Our Ref: EN010090

Date: 26 April 2018

Application by DS Smith Paper Ltd for an Order Granting Development Consent for the proposed Kemsley K4 CHP Generating Station

Advice following issue of decision to accept the application for examination

Document number  
4.9

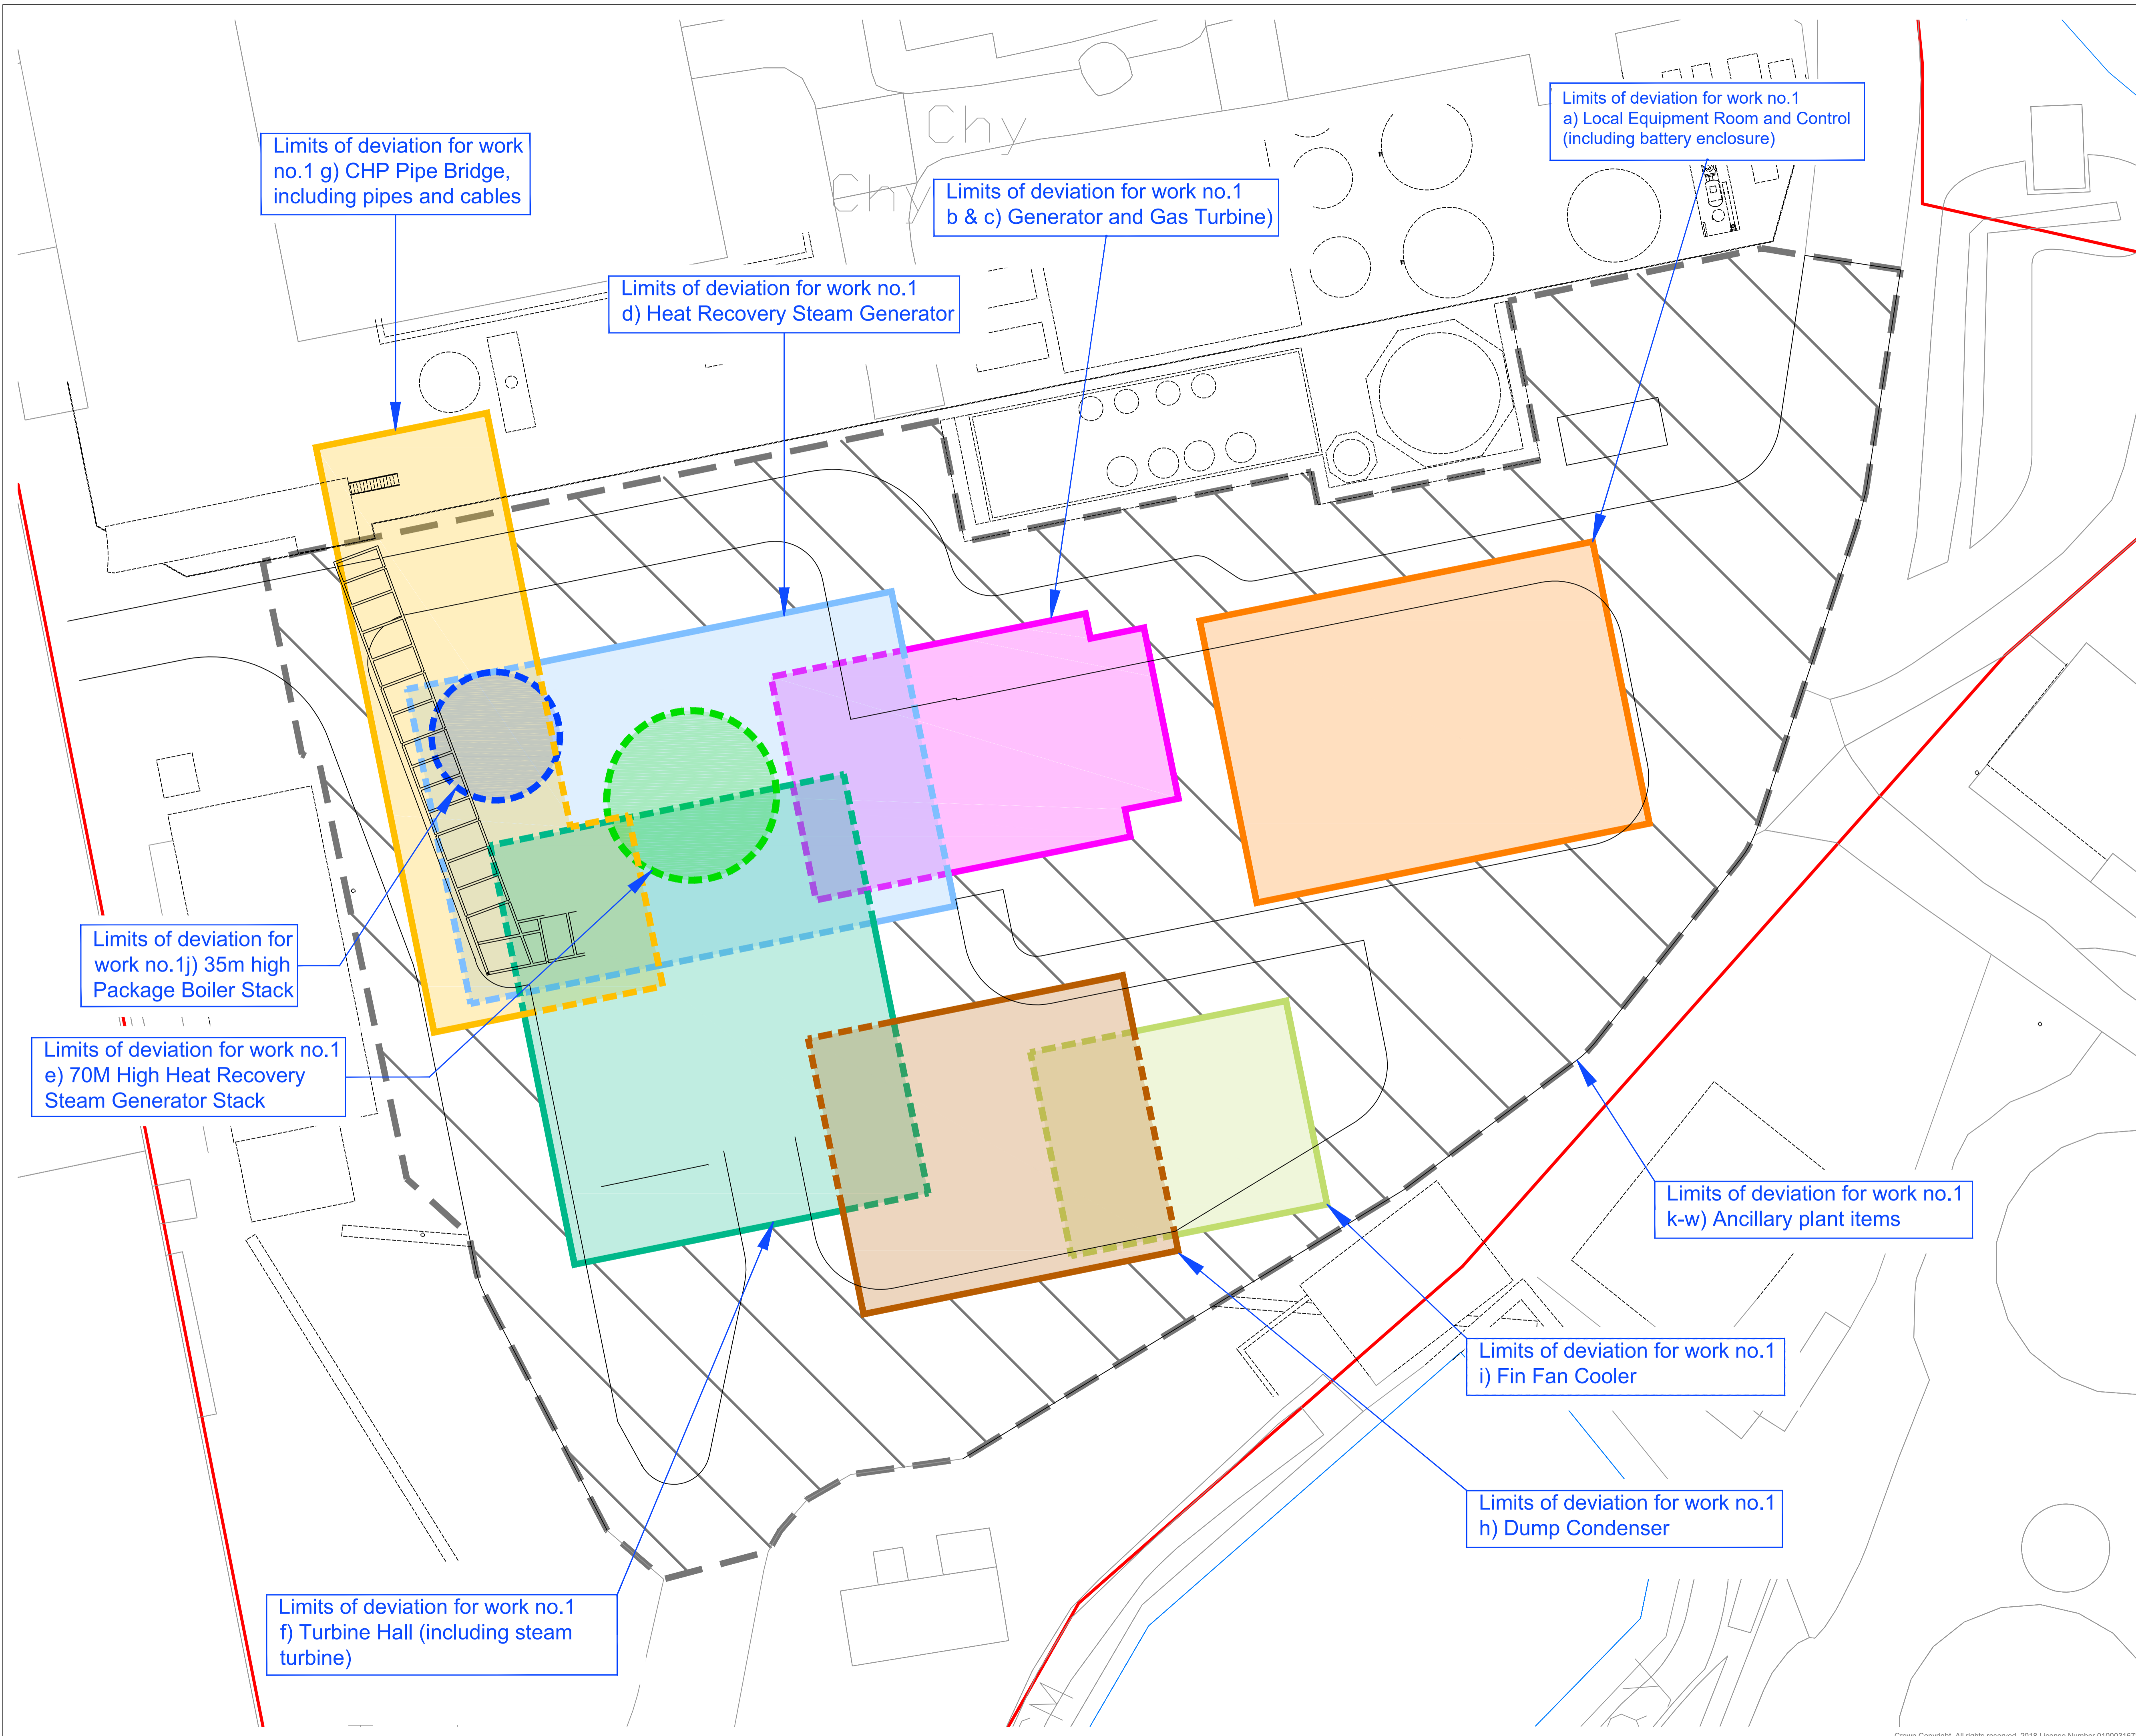
It is noted in the checklist (**Box 30**, Regulation 5(2)(j)) that *Work No.1 – Works Plan with limits of deviation for vertical tube boiler* (Doc 4.9), depicts works number 1(g) ("CHP Pipe Bridge, including pipes and cables") slightly outside the Limits of Deviation (LoD) shaded yellow. There appear to be some discrepancies regarding the positioning of the CHP pipe bridge, upon review of Doc 4.9 and Doc 4.10 in conjunction and it would be helpful, if the Applicant could provide a plan to show clearly the relationship of work number 1(g) to the Works and LoD.

Based on the documents provided, it appears to the Planning Inspectorate that the positioning of the CHP pipe bridge, in relation to the vertical tube boiler should be as that depicted on the plan entitled *Illustrative layout with vertical tube boiler* (Doc 4.10), which illustrates the laydown of the CHP pipe bridge at a 90° angle.
